City of Albuquerque Stormwater Construction Site Inspection Report

ESC File No.	D16E002H	Project Name:	Apple Canyon Gourmet		
NPDES Id. No.	NMR10048T	Location:	1301 Cuesta Abajo Ct NE		
2/28/2022	Owner	Contractor			
Operator	Cloche, LLC	Mickrich contractors			
Contact name & title	Greg Shawver	Jim Rich			
e-mail	Greg@applecanyon.com	Jim@mickrichcontractors.com			
Contact Phone #	332-2000	823-9782			
COA Inspector	Doug Hughes	Start/End Time:	11AM		
Construction Phase:	Stabilization				
Type of Inspection:	Regular	Storm Event	Past Storm Event >0.25"	311/Complaint	Follow Up
Weather at time of inspection?		clear		Temperature: ~	50
Estimated date of last storm 0.25" or greater		1/1/2022

SHEET NO.  
C-101

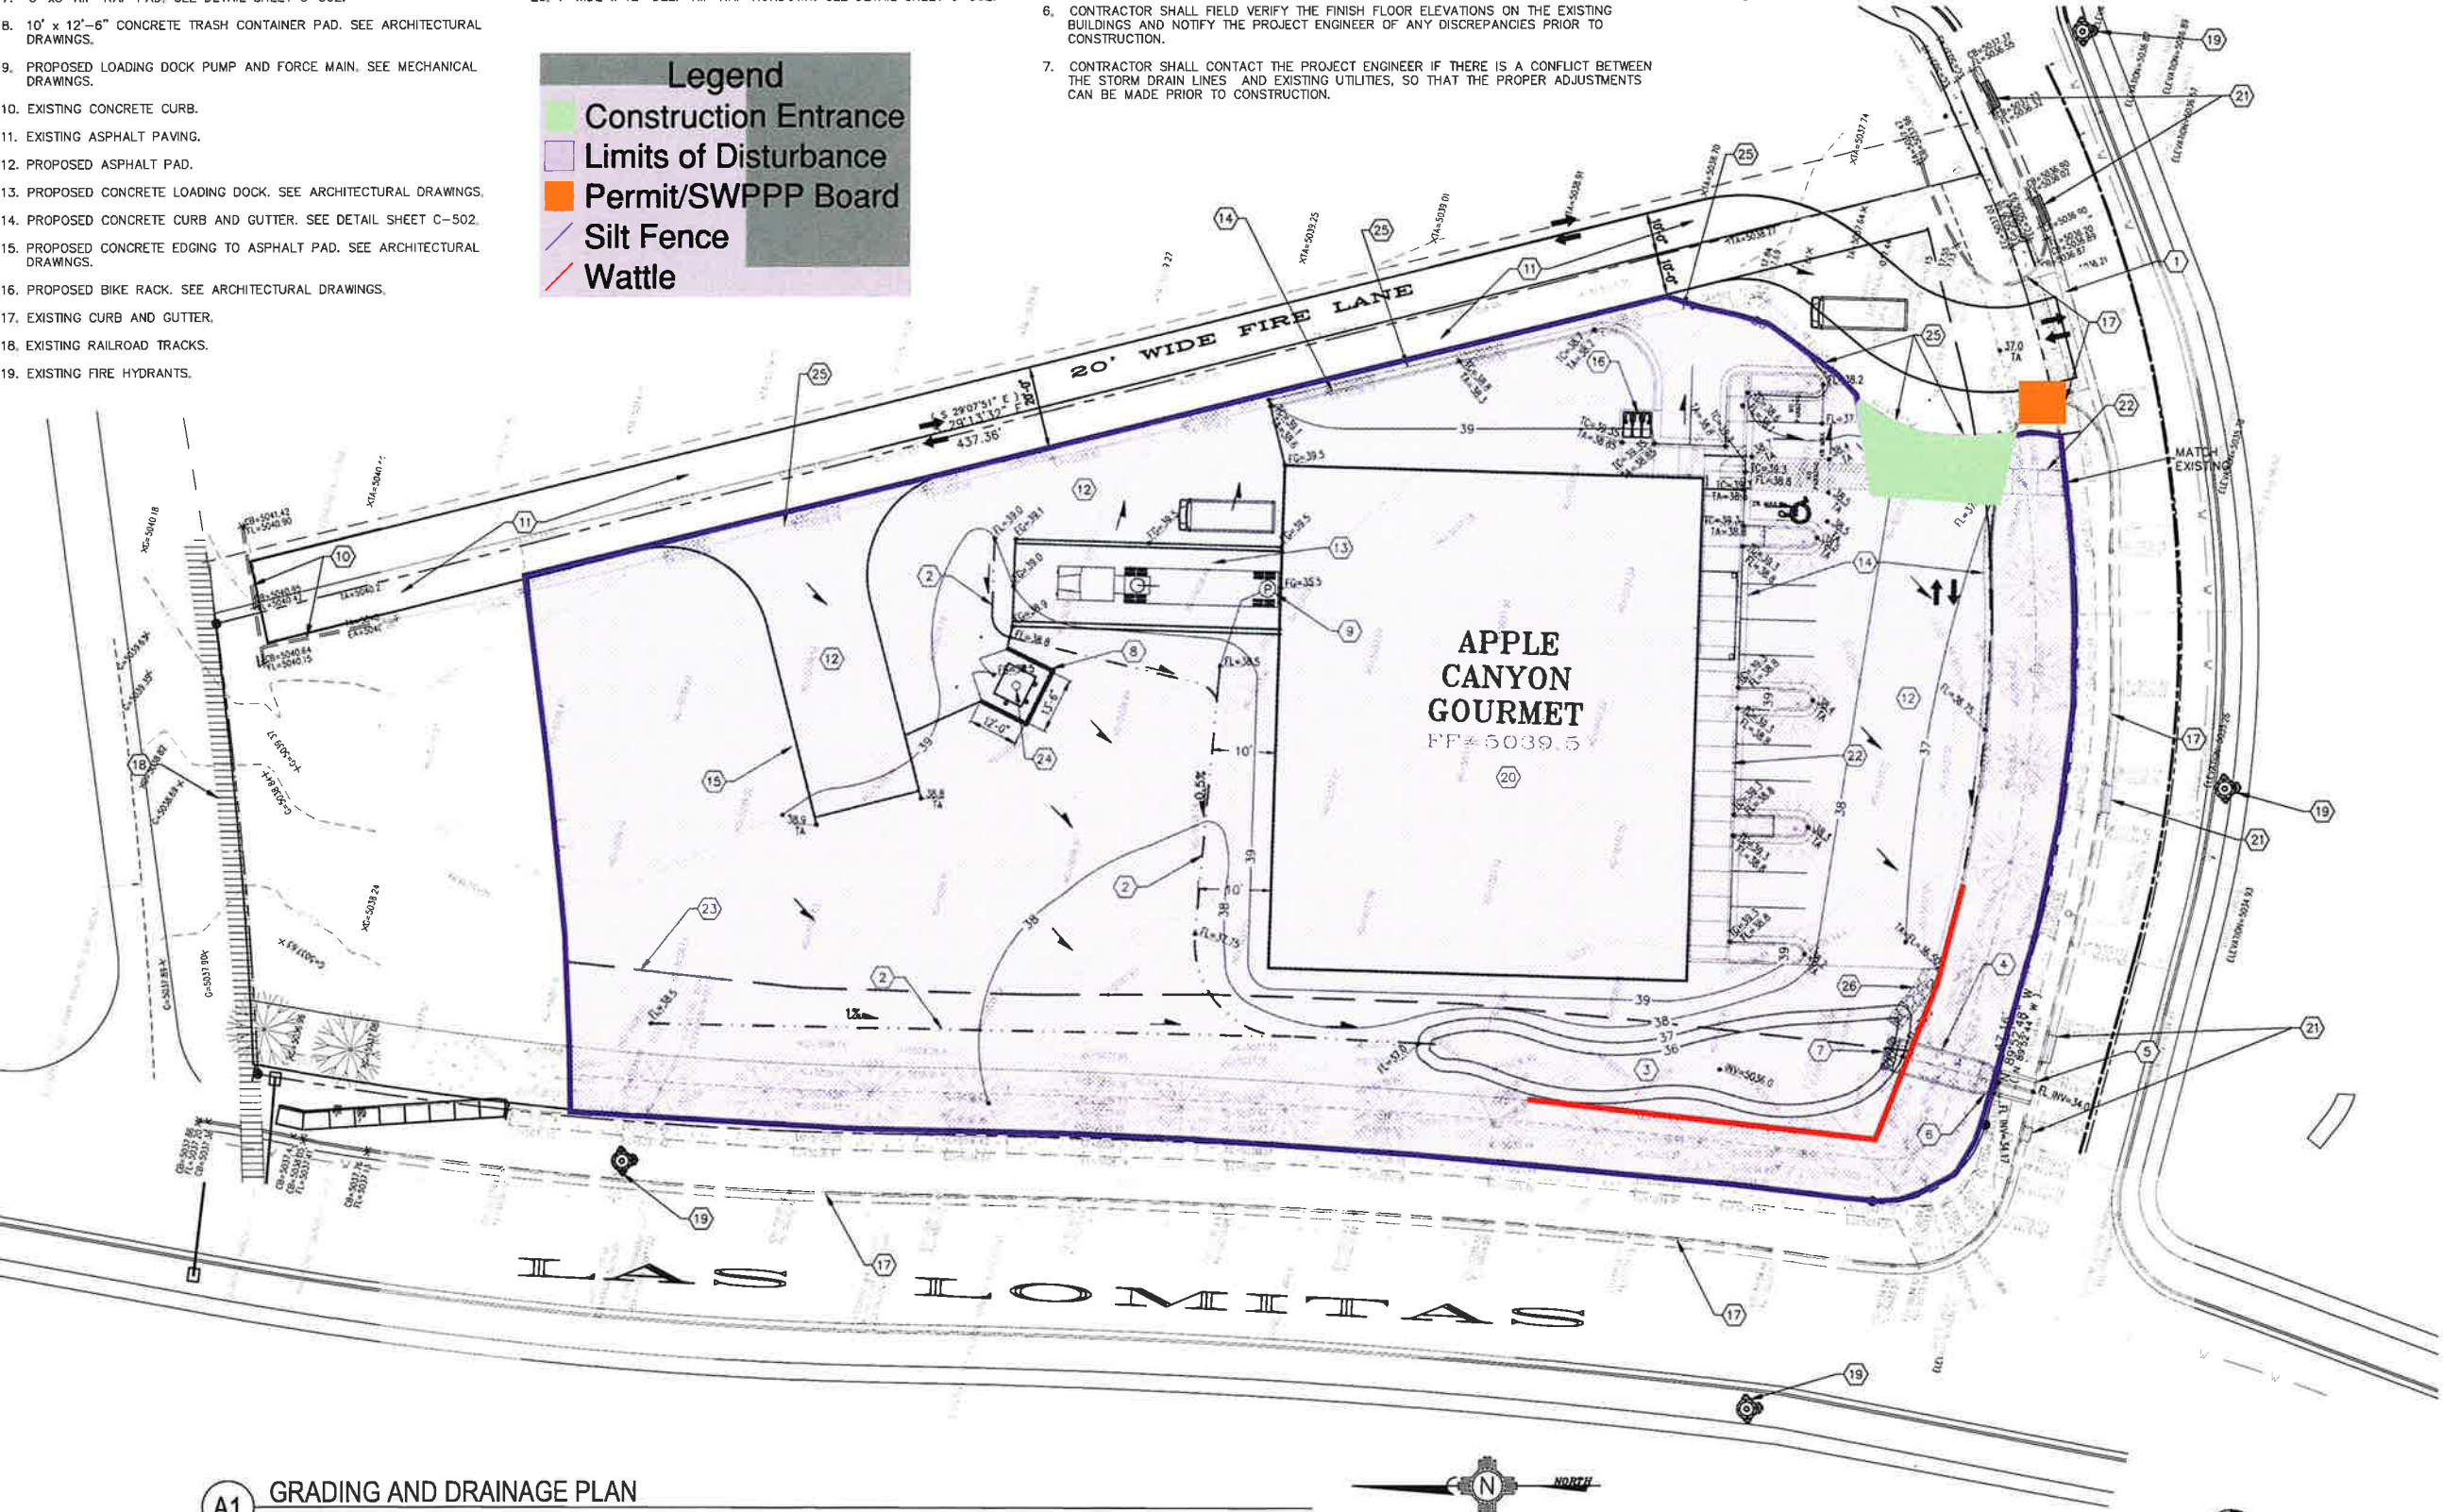
Item Number	Deficiency/ Corrective Action				
1	SWPPP not up-to-date. Missing map, operator signatures on SWPPP, and Self-inspection Reports. The up-to-date SWPPP must be available on-site.				
2	Sediment in adjacent parking lot at Cuesta Abajo entrance, and trackout pad not positioned correctly and covered with sediment. Either permanently close the entrance or reset the trackout pad to full width of entrance, and pickup and remove sediment on adjacent pavement.				
3					
4					
5					
2.1	Discharge off site? (Y/N)	no			
4	Self Inspection Reports	Requested	Latest report Date:	2/24/2022
